**Application no:19/01036/HYBRID**

**Location:** Bicester Eco Town Exemplar Site Phase 2 Charlotte Avenue Bicester

## **Local Lead Flood Authority**

**Officer's Name:** Richard Bennett  
**Officer's Title:** Flood Risk Engineer  
**Date:** 05 December 2019

Appendix E - Drainage Strategy

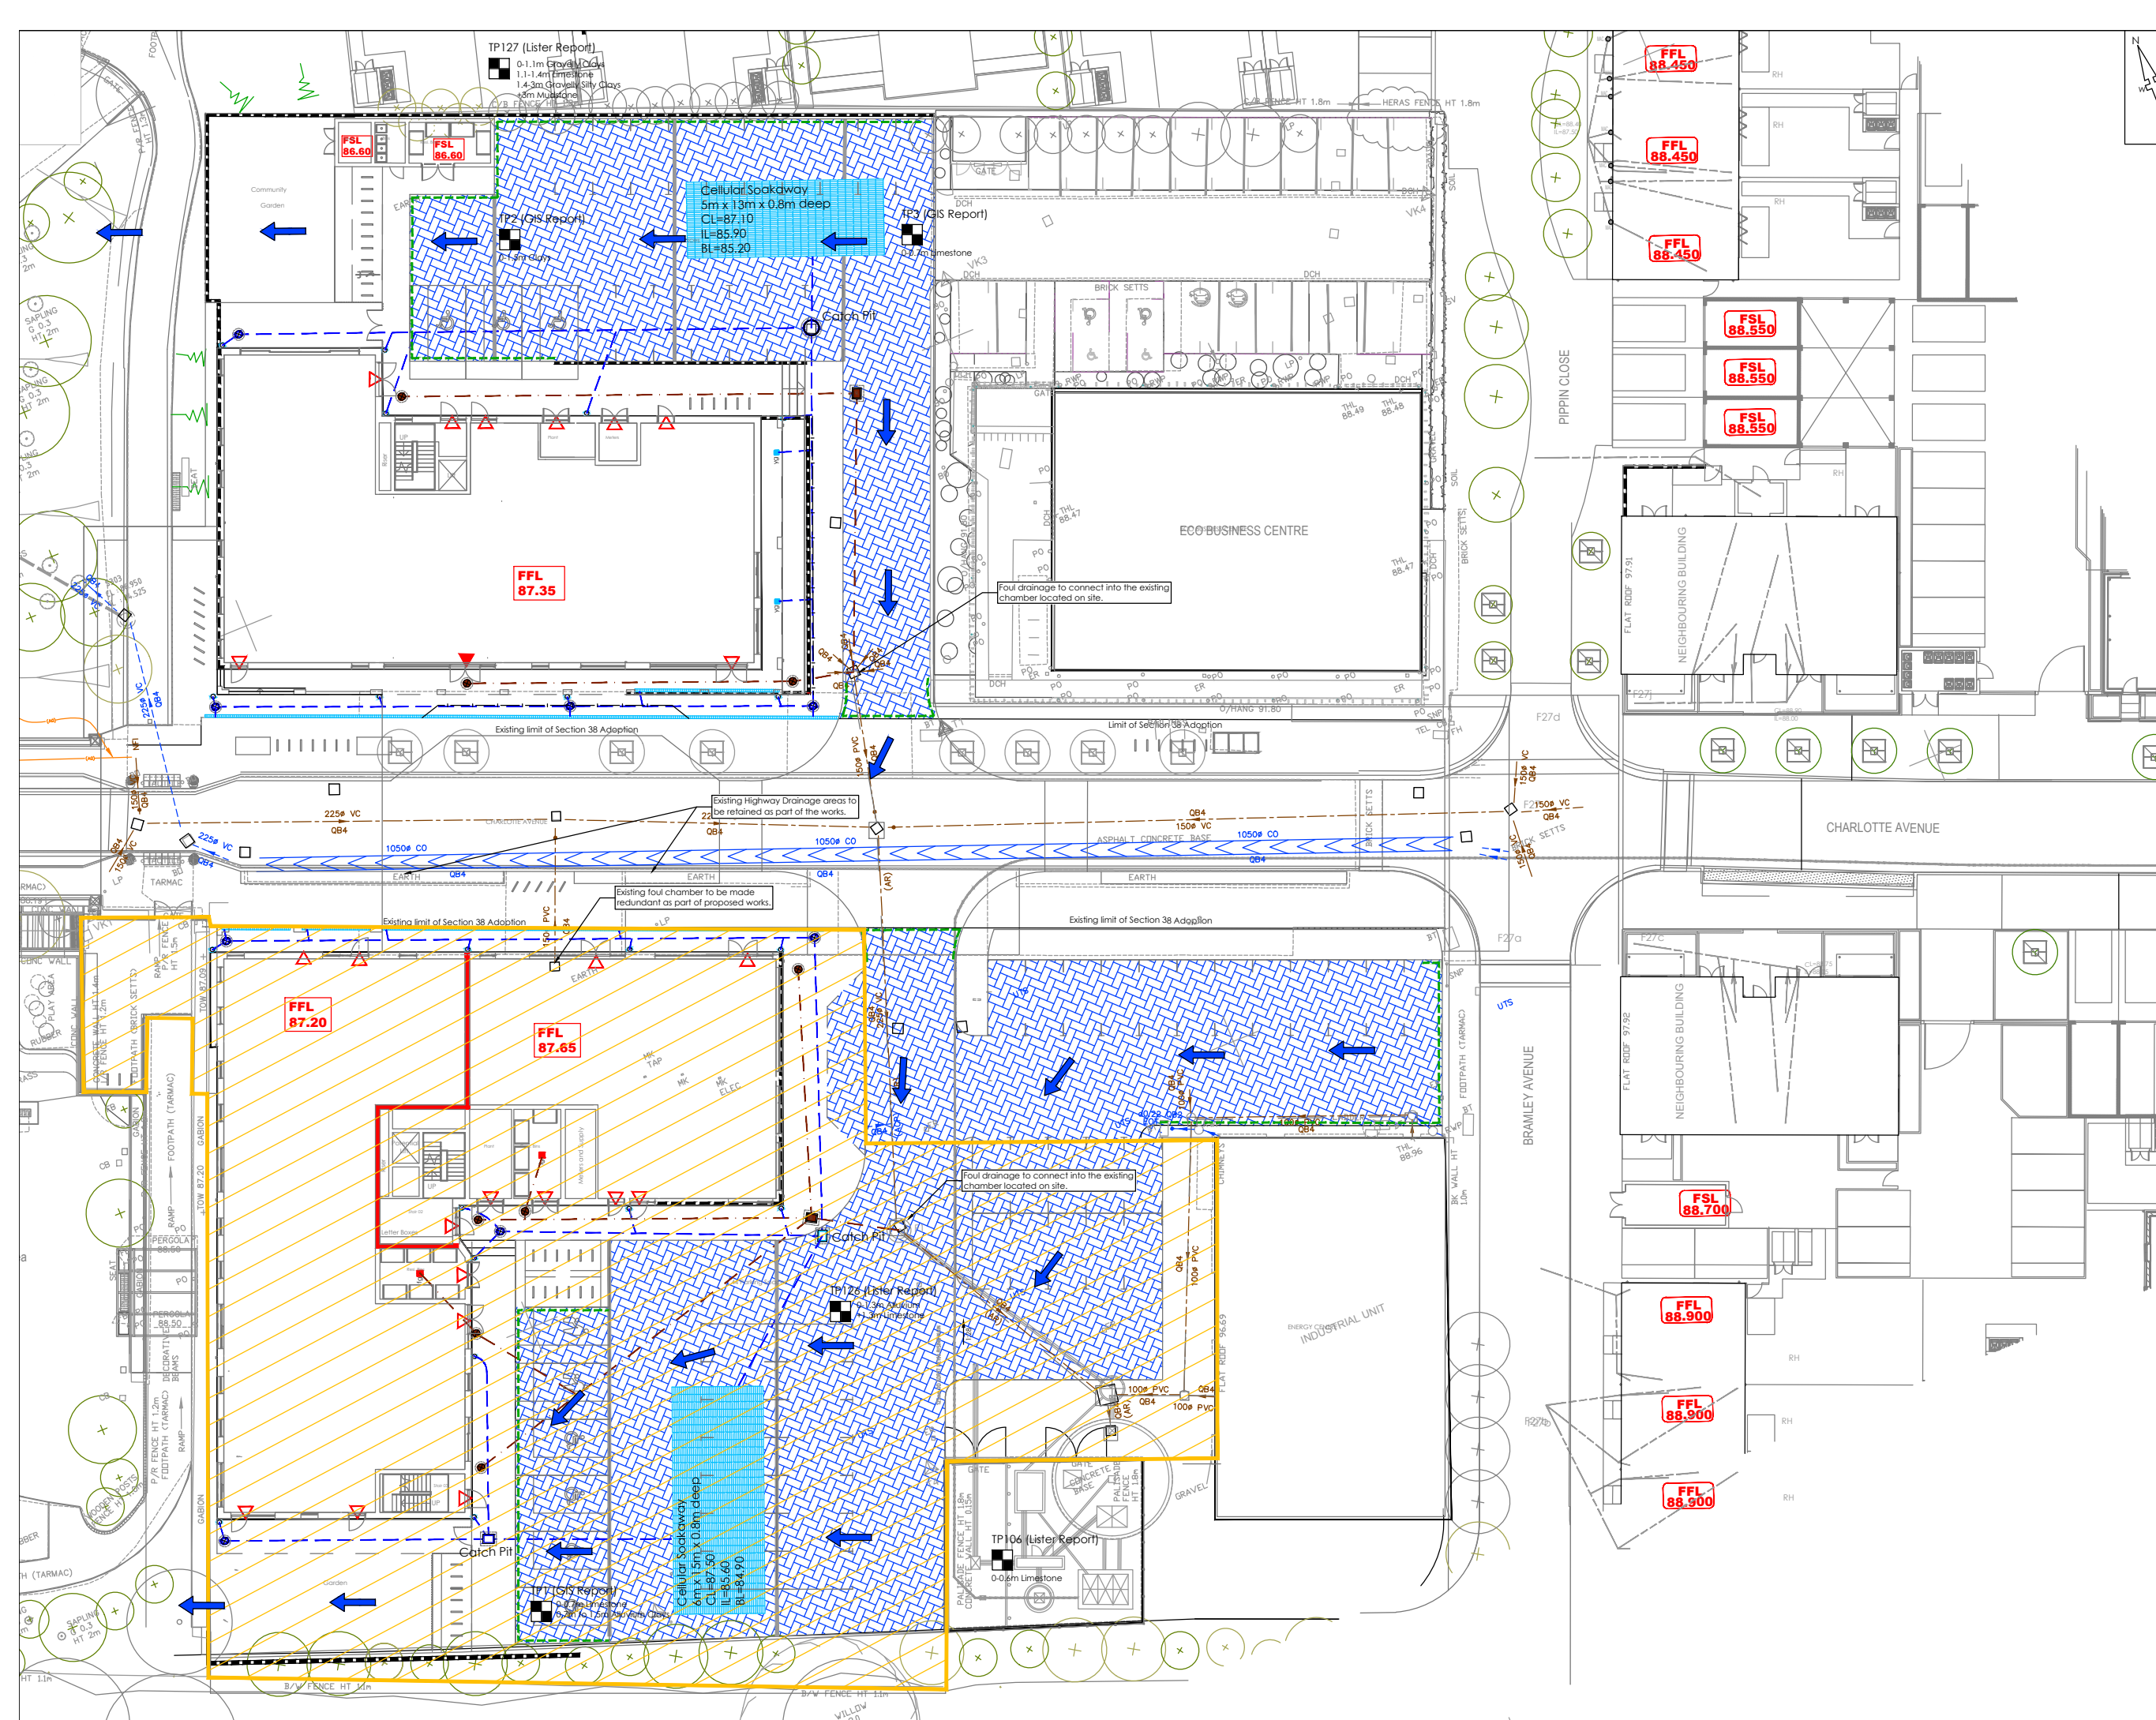
There are concerns over the proposed soakaways which are proposed to be 1.9m and 2.6m deep. The site investigation only carried out trial holes to 1.5m depth at the site. The site is in close proximity to the floodplain and therefore it is likely that

soakaways at this depth will be affected by groundwater. The design is likely to need to be amended to provide shallower soakaways to ensure the depth of the infiltration systems are 1m above groundwater, or an offsite connection to a drainage system is required.

Development shall not begin until a detailed surface water drainage scheme for the site, in accordance with the Infrastruct CS Ltd Flood Risk Assessment and Drainage Statement October 2019 Document reference: 2346-BBH-ICS-XX-RP-C-07.001, has been submitted to and approved in writing by the local planning authority. The scheme shall subsequently be implemented in accordance with the approved details before the development is completed. The scheme shall also include:
